Rezoning Petition Review

Rezoning Petition #: 08-144

Location of Property: Approximately 2.60 acres located northwest of the intersection of E. Independence Blvd. and Sardis Road North

RZ1

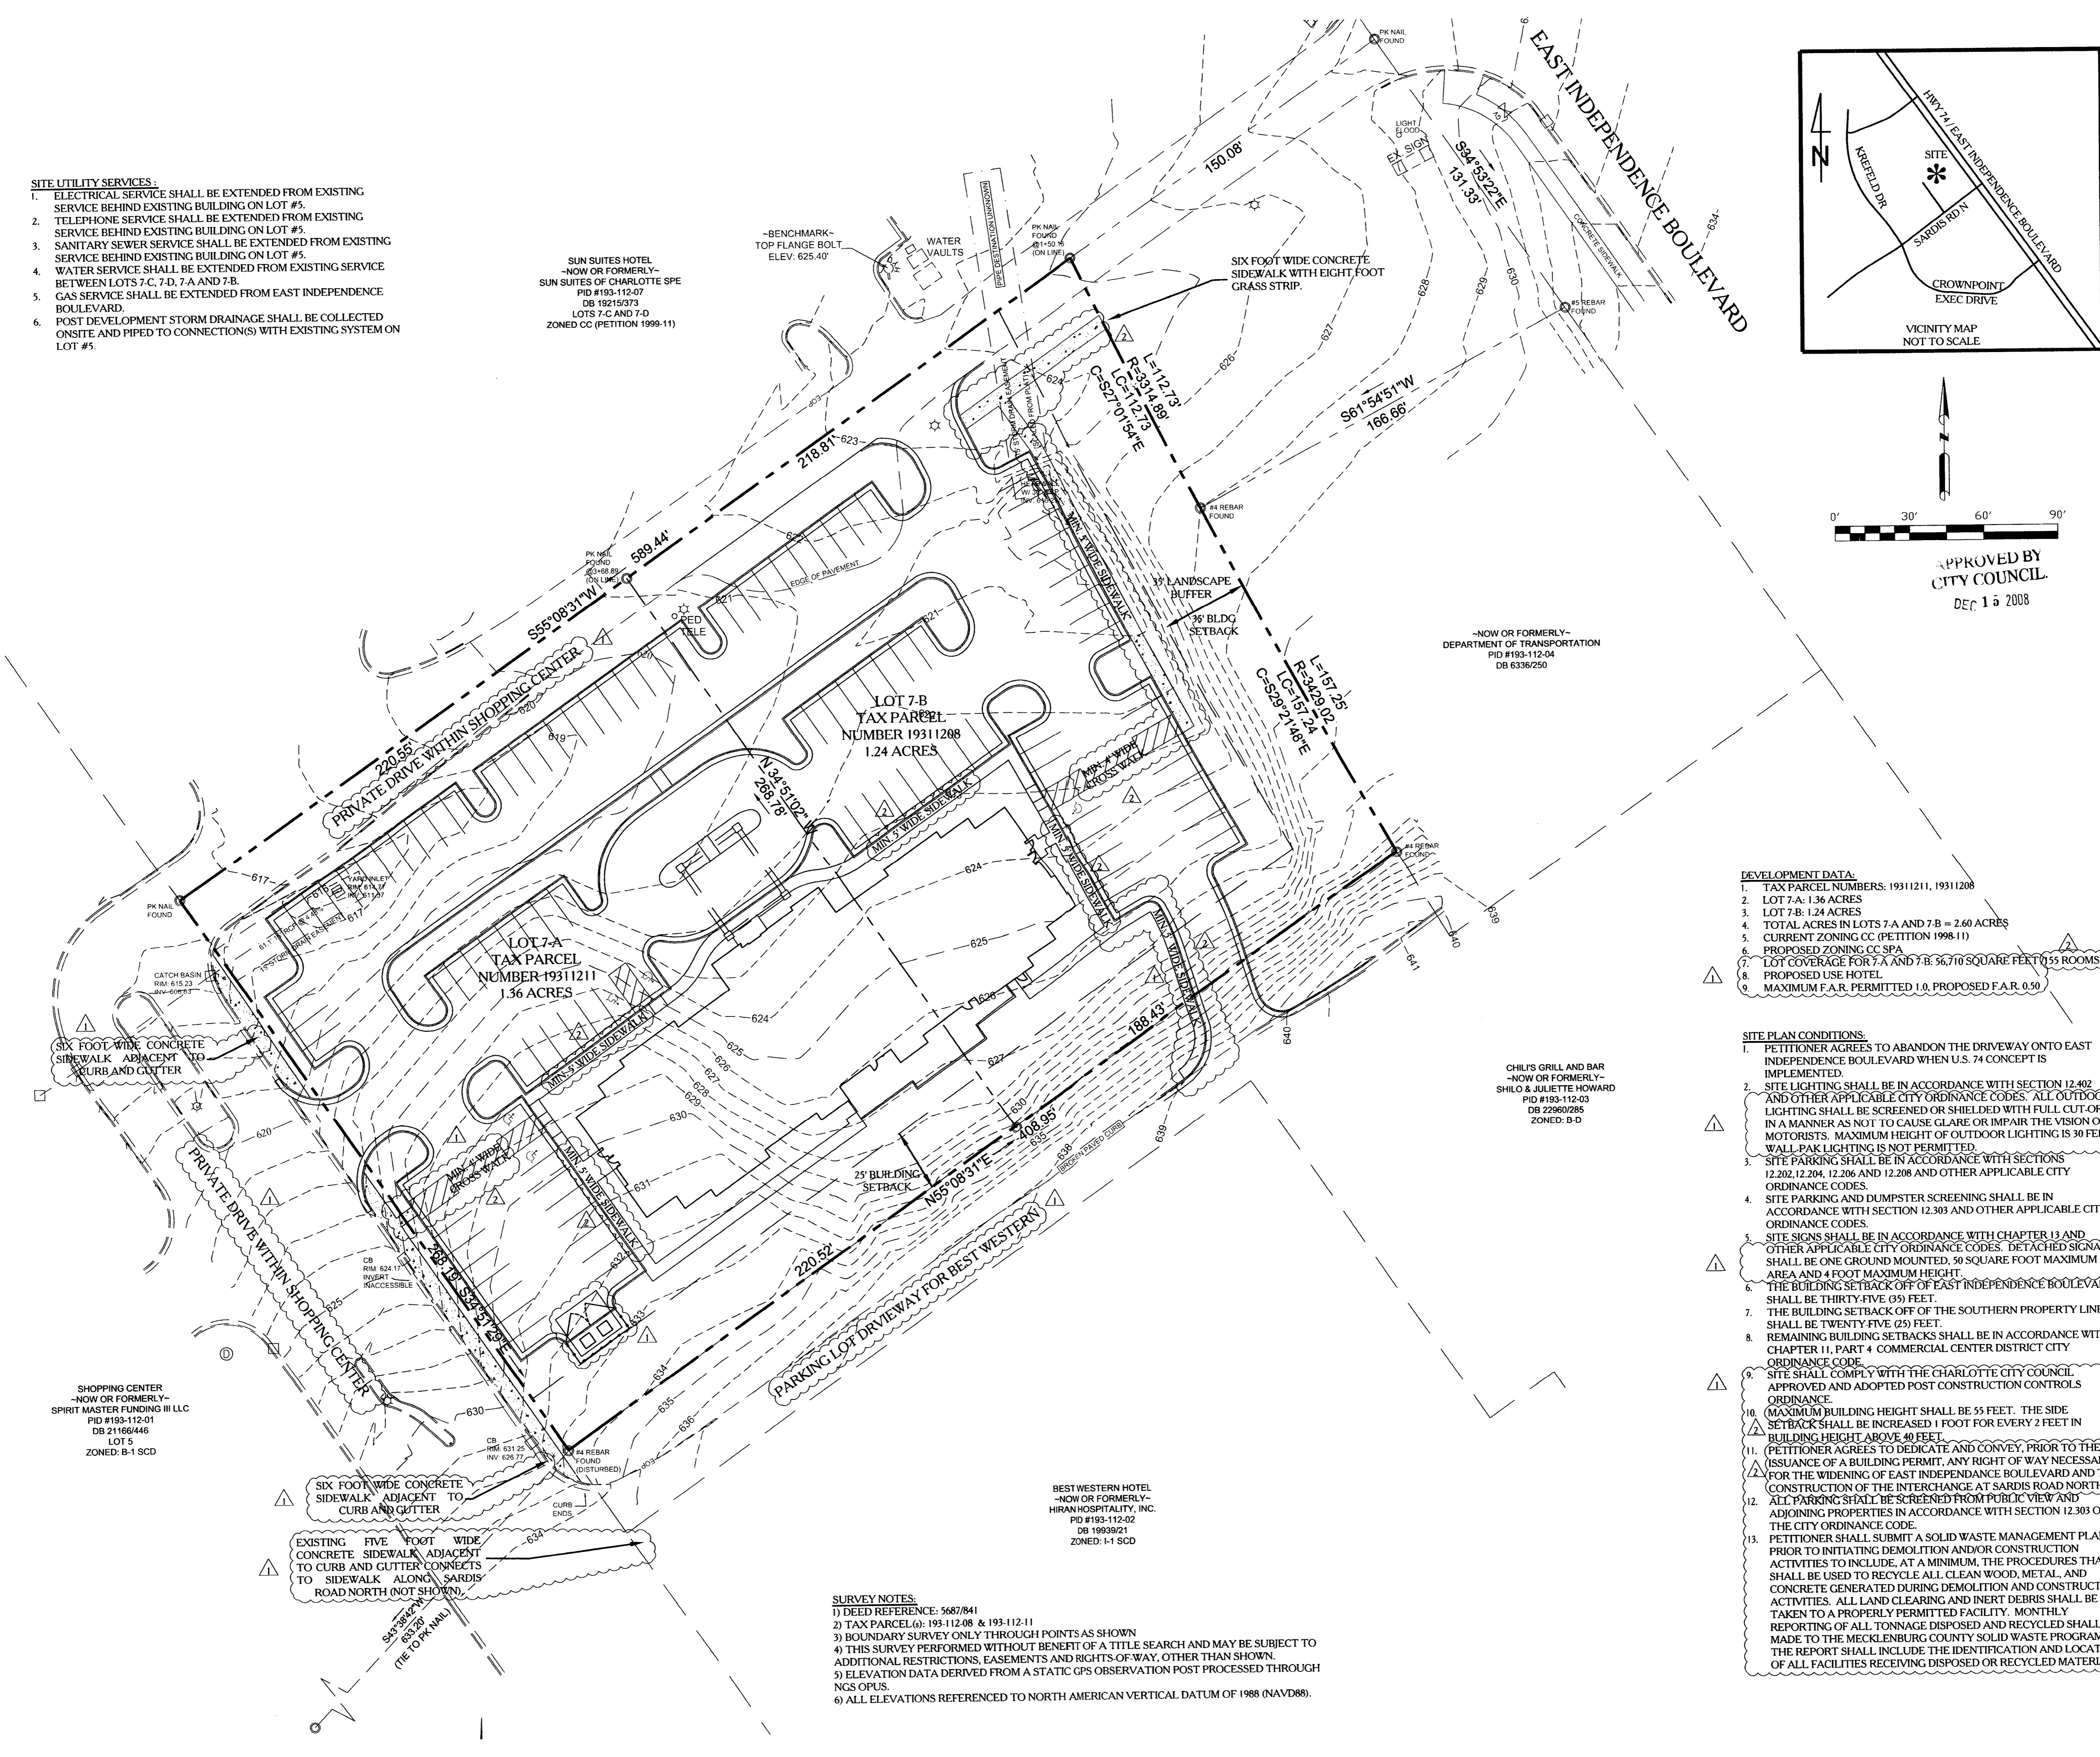
Concerning Storm Water: **Please add the following note:**

The petitioner shall comply with the Charlotte City Council approved and adopted Post Construction Controls Ordinance.
